3/2016/0327 – 10 The Hazels

The application is for: New extension to rear. Loft conversion to create additional bedrooms and additional bathroom. New dormer windows to front and rear of premises. New balcony area above ground floor extension.

.WPC – object to this application on the following grounds:

DWG. DESCRIPTION
Existing & Proposed Rear Elevations

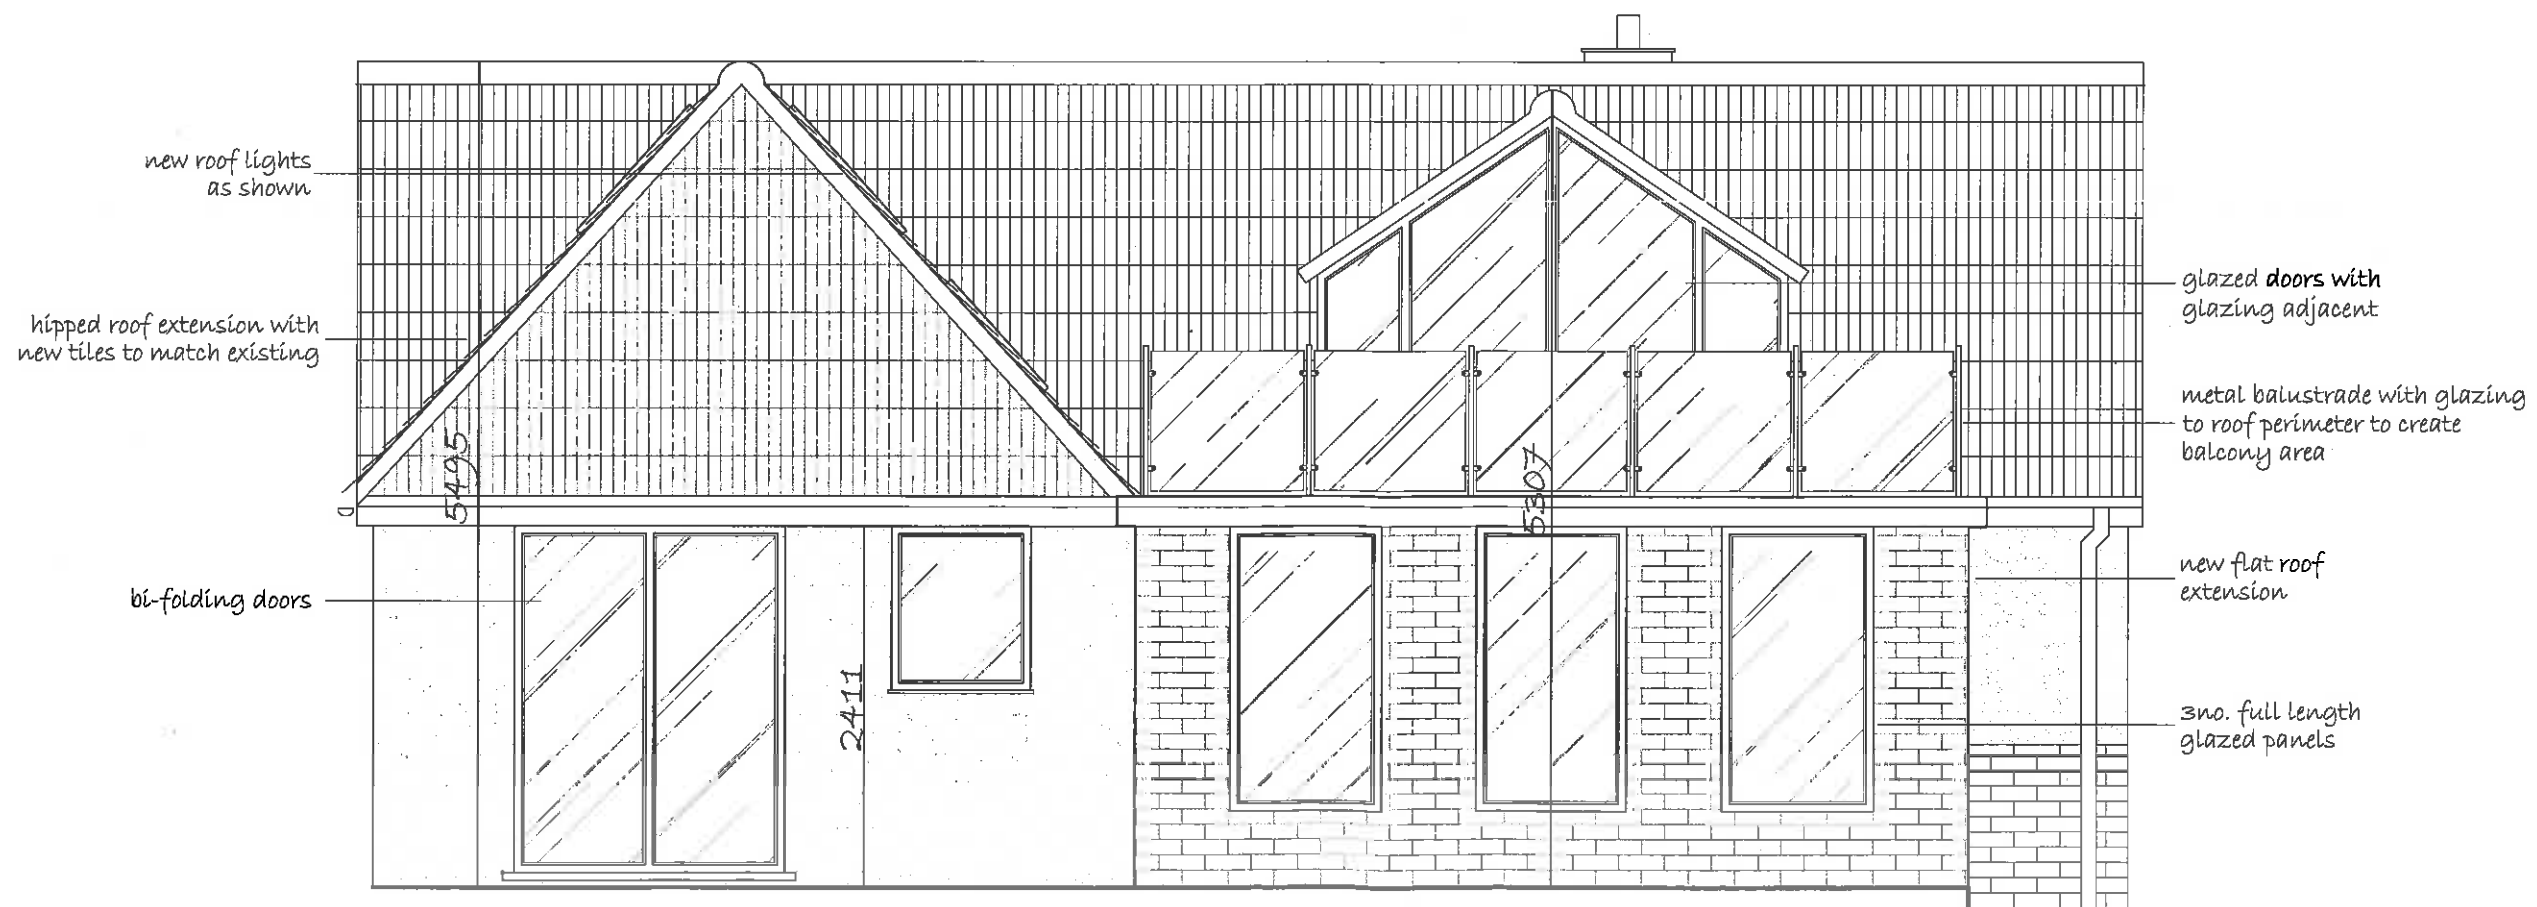
Loss of amenity for neighbouring properties from the proposed balcony.

H.M. LAND REGISTRY		TITLE NUMBER	
LA295913			
ORDNANCE SURVEY PLAN REFERENCE	COUNTY	NATIONAL GRID	SECTION
	LANCASHIRE	SD 6832	B
Scale: 1/1250			
© Crown copyright 1971.

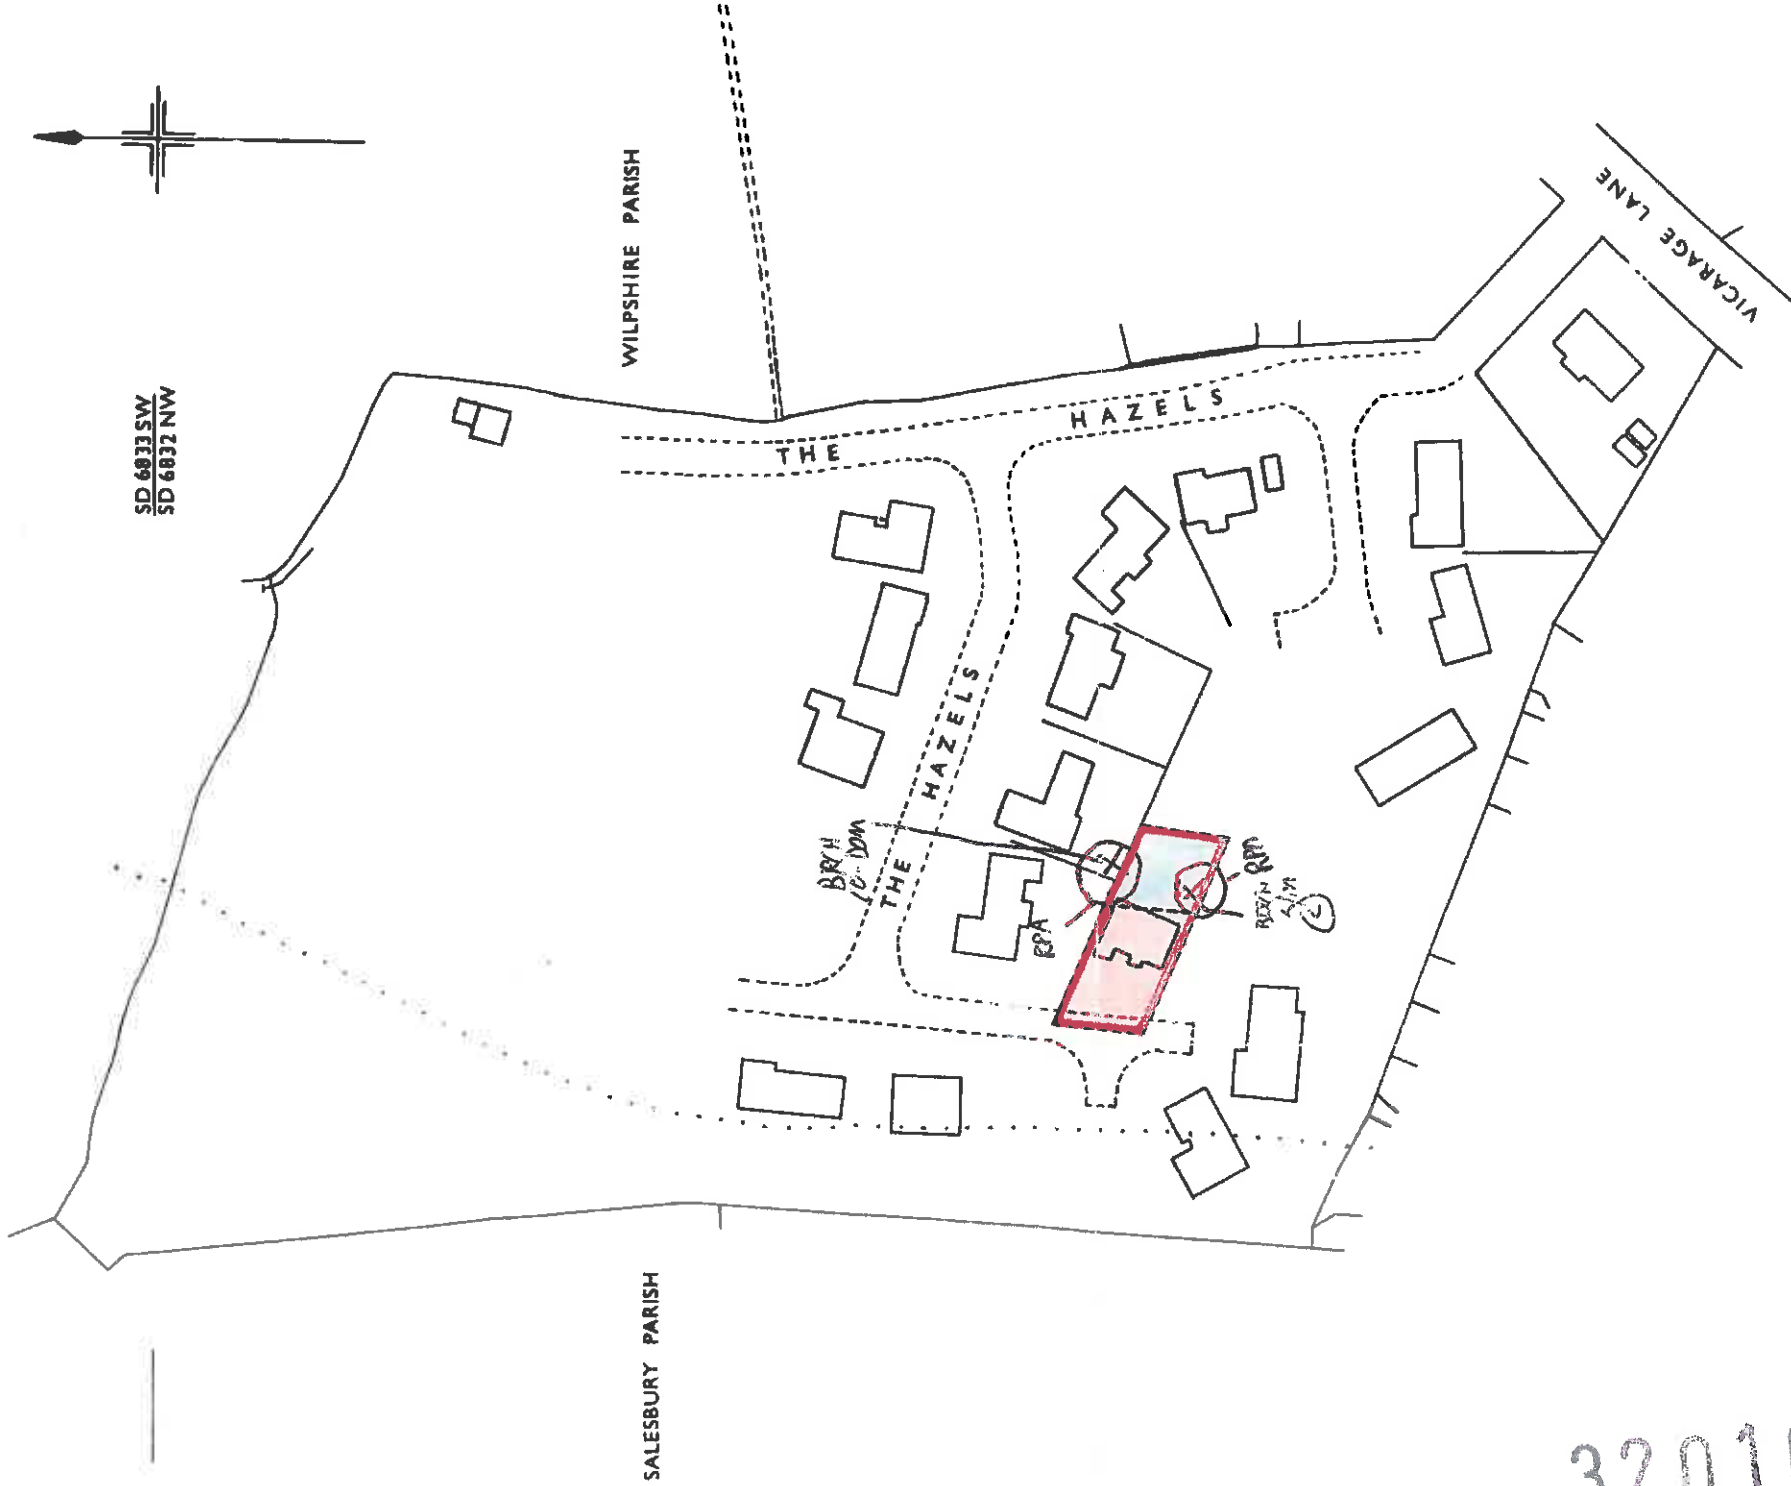
It is also believed that a property has been missed off the location plan (4?
